RE: Formal Objection to SSD-94006708 Mixed Use development at 15-21 Cottonwood Crescent, (also referred to as 88 Waterloo Road) Macquarie Park and the Concurrent Rezoning Proposal

I am writing, as a resident in the nearby Natura apartment building located at 82 Waterloo Road, Macquarie Park NSW to object to the excessive building height and FSR proposed in the above application on the following grounds:

LANDSCAPE PLAN ELOUERA RESERVE INTERFACE

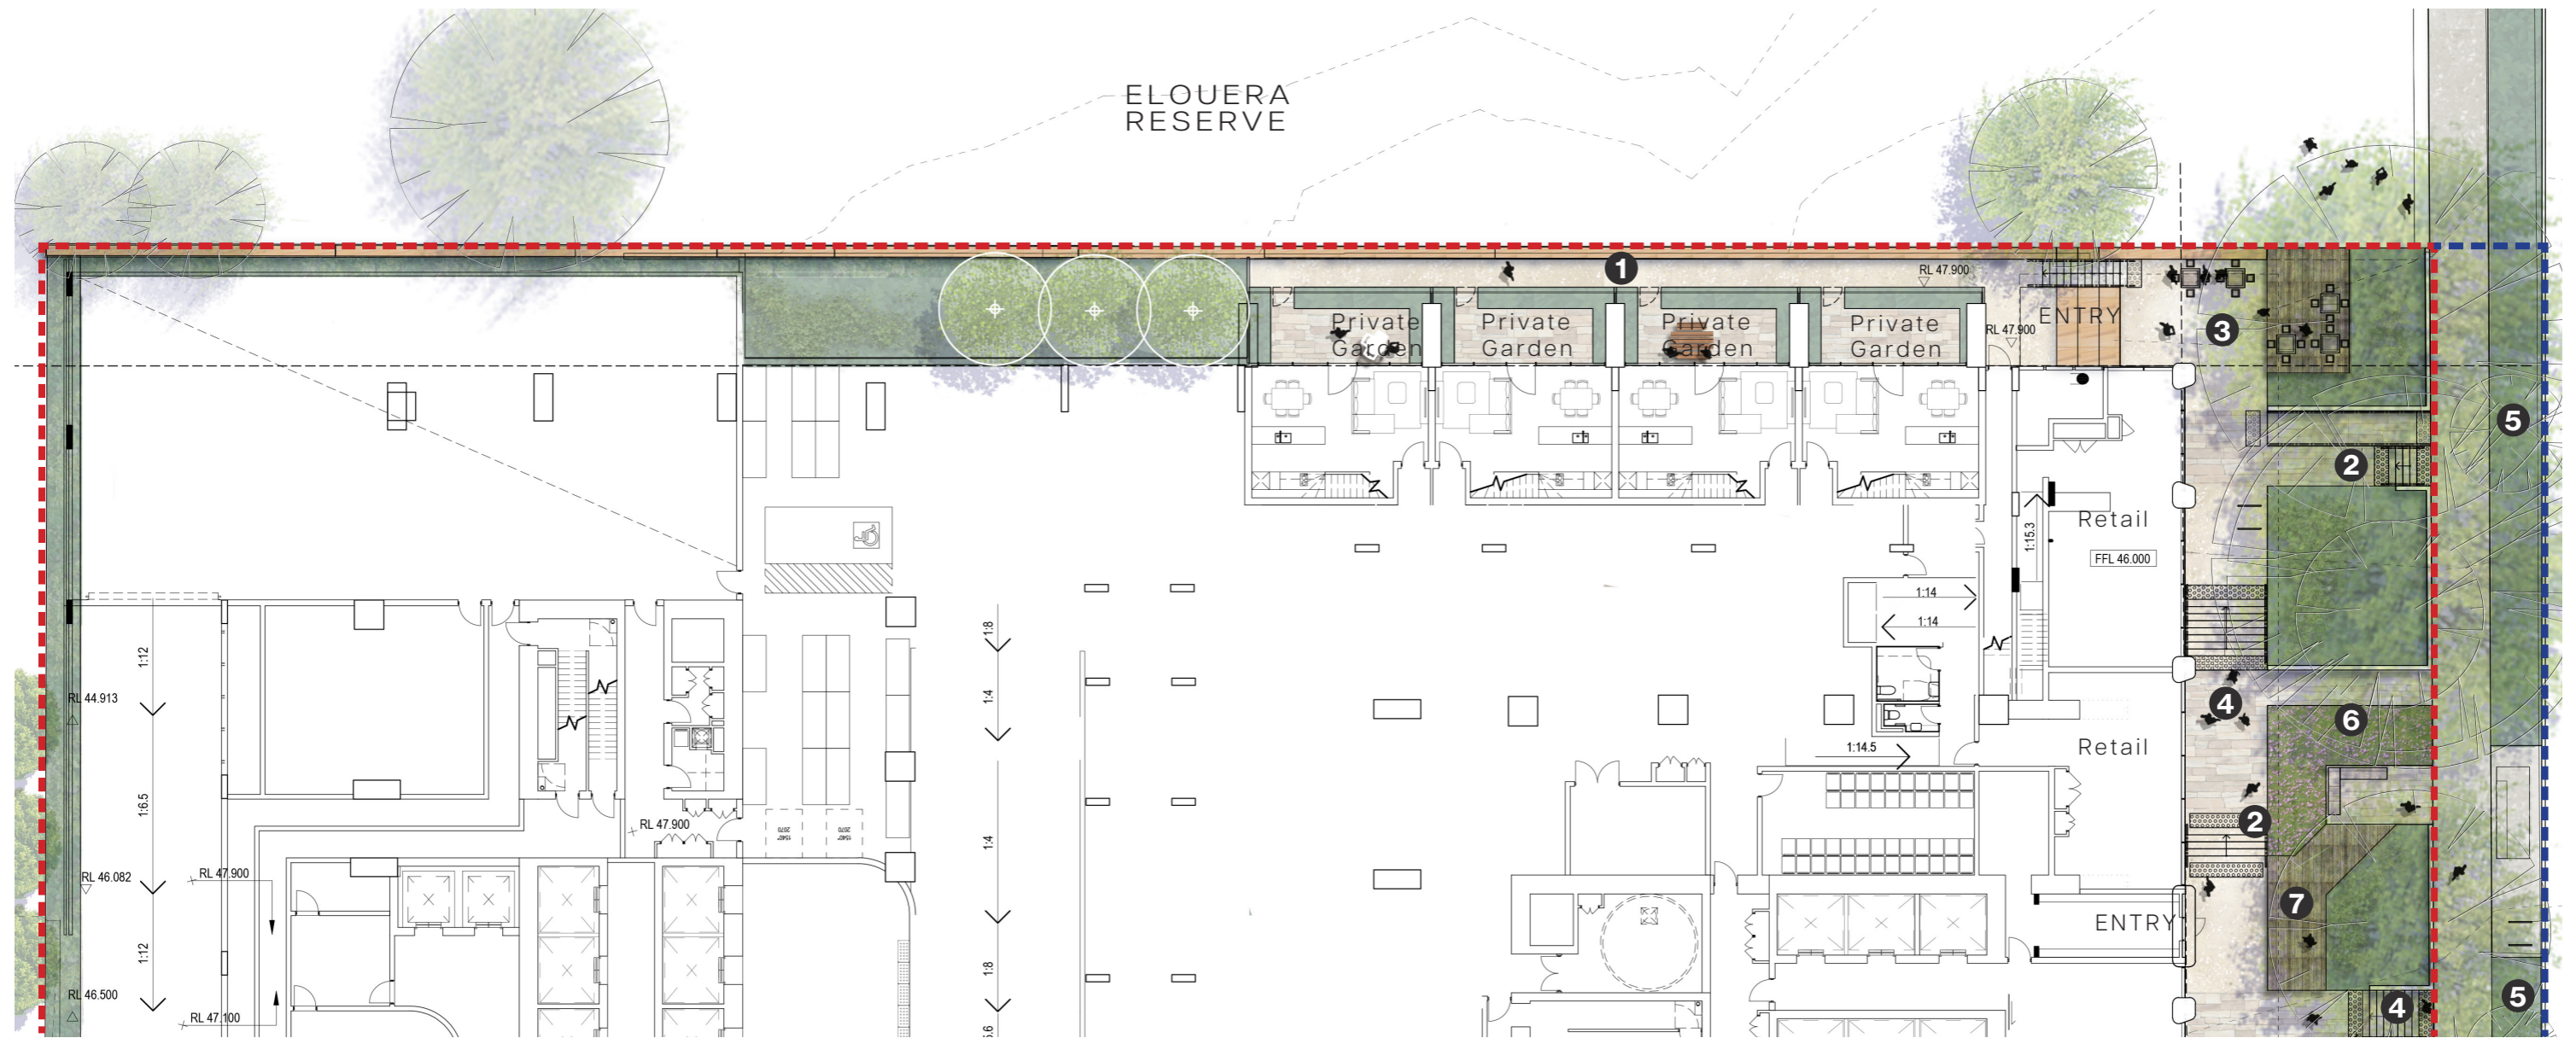
10. While the boundary setbacks may be compliant, they are inadequate for the scale of this building with a tight knit residential area to the south-west and narrow road reserve on Cottonwood Cres while the four storey podium (necessary to accommodate the car parking) fronting Elouera Reserve's entire eastern edge with only a circa 3m setback will leave Elouera Reserve feeling confined and uninviting.
